# ENG-SF21012-R1-Plat-redlines.pdf Markup Summary

PCD File No. SF-21-012

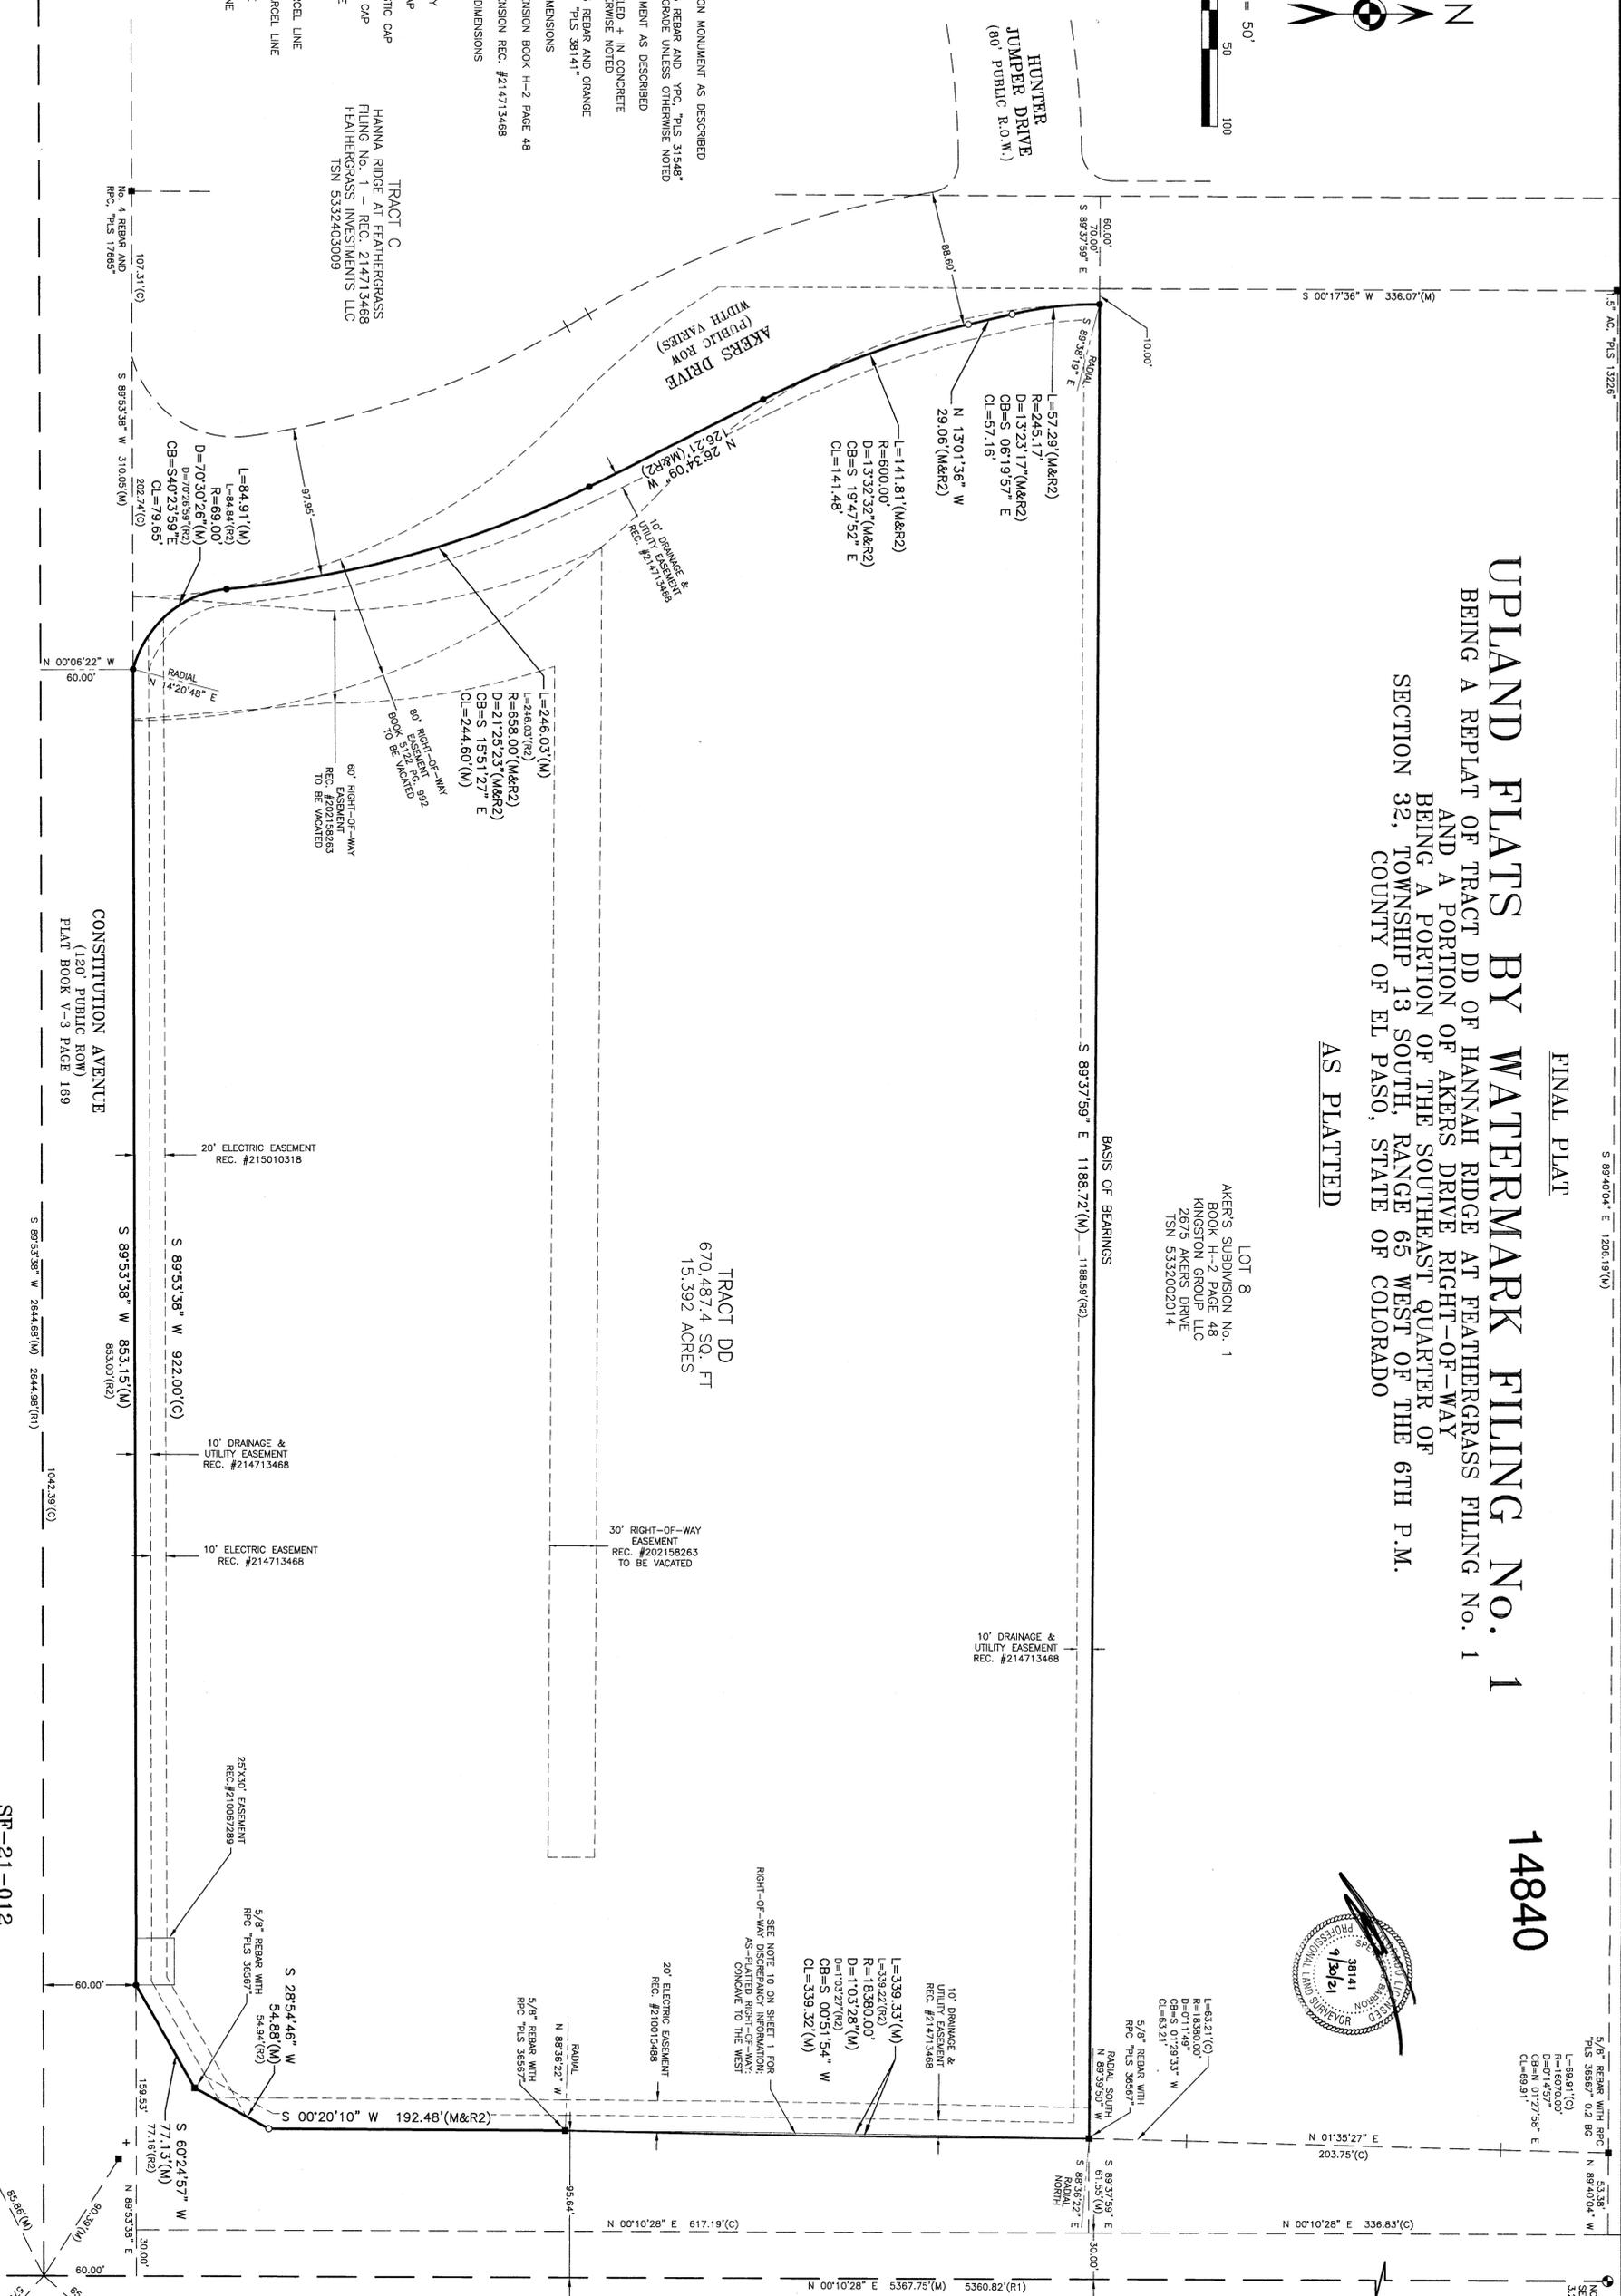
label & depict CSU's two easements and identify if they are to be vacated by this plat instrument, provide documentation that the easement holder is agreeable to the vacation.

Noise mitigation is required....Depict setback, or wall, and provide corresponding notes... Add to FAE

label & depict CSU's two easements and identify if they are to be vacated by this plat instrument, provide documentation that the easement holder is agreeable to the vacation.

The adj subdivision has provided the 7.5-foot Public improvement easement along Constitution verify with Engineering this is necessary or not with this plat.

150- foot setbacks are suggested for mitigation in Noise study from Marksheffel

100-foot setbacks are suggested for mitigation in Noise study constitution

25- feet of fall through site. Grading plan ? retaining walls? We need this info w plat to guarantee improvements w SIA. There is a pond shown with no GEC .

sidewalk to be provided by applicant and depicted on CDs and site dev plan

Easement at Rec. No. 215010318?

Title commitment B2 #10 show or note that this cannot be located : RIGHT OF WAY EASEMENT AS GRANTED TO COLORADO INTERSTATE GAS CO. IN INSTRUMENT RECORDED SEPTEMBER 26, 1934, IN BOOK 908 AT PAGE 91.

Show the 20' ROW dedication per TIS.
